**Former Shredded Wheat Factory Phase 1 (Planning Permission Reference: 6/2018/0171/MAJ)  
Non-material Amendment**

On behalf of our client, Metropolitan Thames Valley Homes, we submit an application pursuant to Section 96a of the Town and Country Planning Act 1990 (as amended) to make non-material amendments to the above planning permission granted on 15 February 2019. Submitted for approval via the Planning Portal are:

1 Block 11 - Ground Floor - Block C
1 : 100 @A1

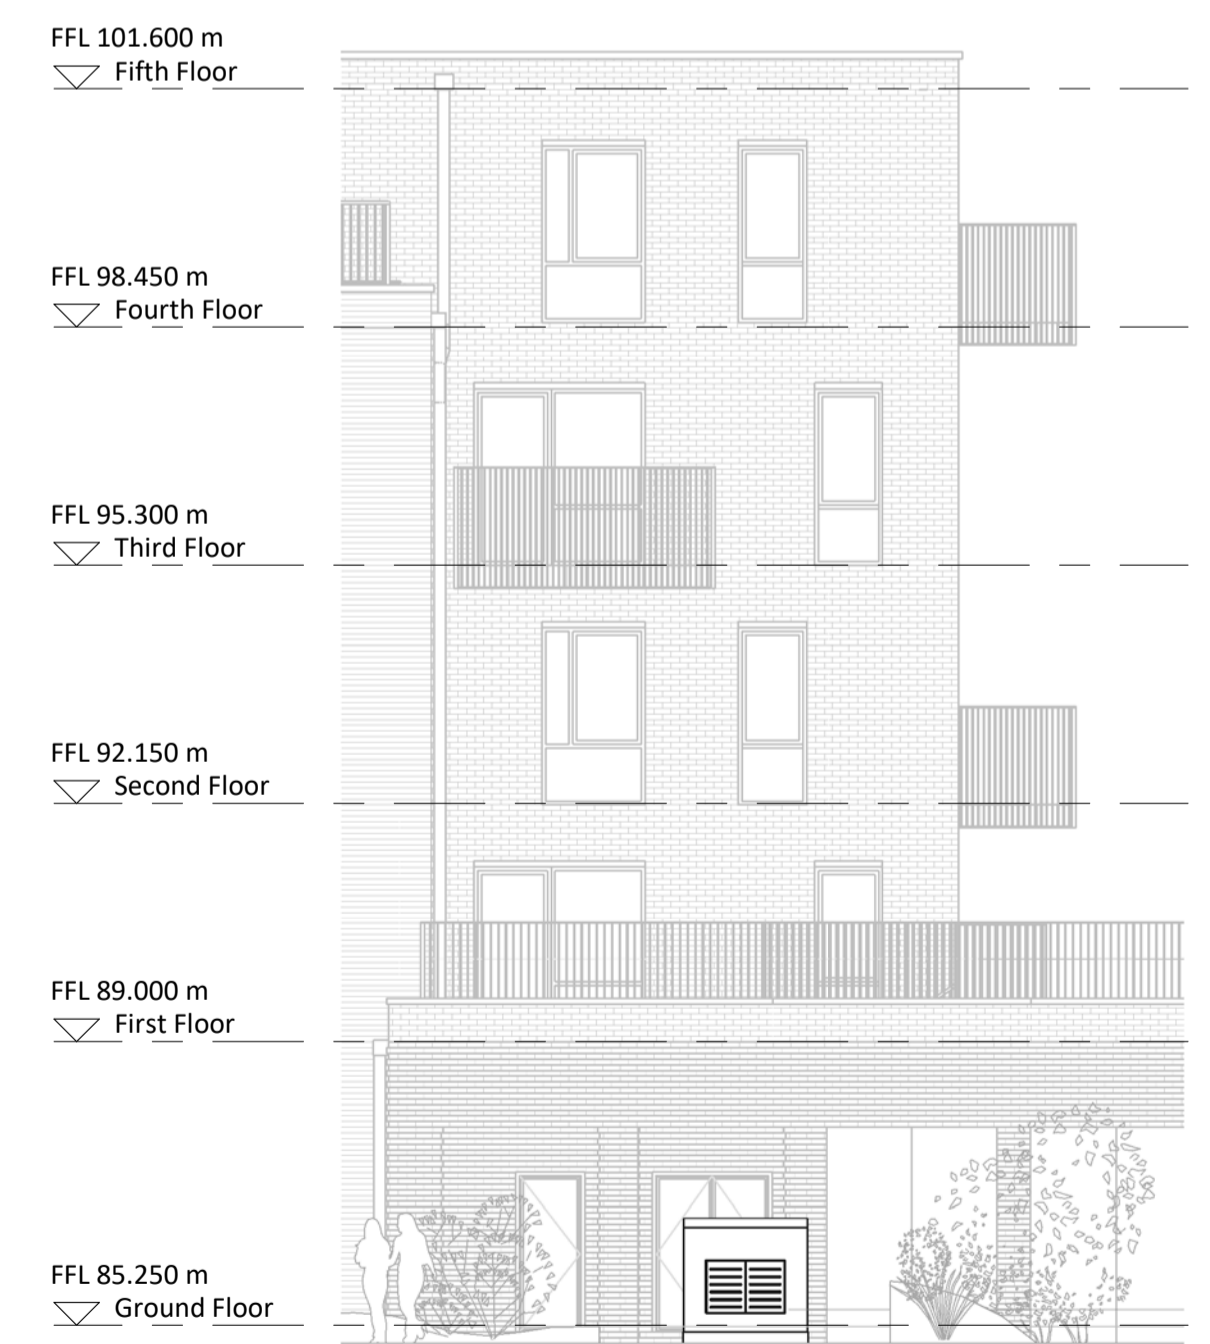
Amendments	Improvements / justification
<p><b>Removal of the brick hit and miss wall to carparks on the North and South Elevation of Block 10 and the North Elevation of Block 11, and replacement with perforated metal panels.</b></p>	<p>Achieves ventilation requirements that cannot be met using hit and miss façade treatment. Furthermore, it achieves improved safety by removing potential use of hit and miss to climb as recommended by the Designing Out Crime Officer. Details of the proposed ventilation strategy and panels proposed are included on drawing references:</p> <ul style="list-style-type: none"> <li>• SWP1-CCA-ZZ-GND-DET-A01-90.200 Rev C3</li> <li>• SWP1-CCA-ZZ-GND-DET-A01-90.201 Rev C5</li> </ul>
<p><b>CHP Flues amended on Block 11</b></p>	<p>The CHP flue height has been amended to take account of the approved energy strategy and to address air quality requirements. The change is due to completion of the detailed design, appointment of a third party ESCO (Switch 2) for the design and management of the energy centre, including the CHP and flue, along with the CHP plant being selected. The proposed finish is stainless steel which is durable and does not require regular maintenance. The stainless steel finish has not changed since the original planning approval.</p> <p>The flues are located away from the building frontage which limits their visibility. Additional views have been provided within the submitted Design Updates Statement (pages 30-33) which demonstrate that this small increase in height would not increase the visibility of the flues at street level to an extent considered to be ‘material’.</p>

<p><b>Internal layout changes to communal and plant areas</b></p>	<p>These minor changes (as listed in the design documents) do not alter the size or layout of the new homes. The changes have been made to address M&amp;E and Building Regulation requirements.</p>
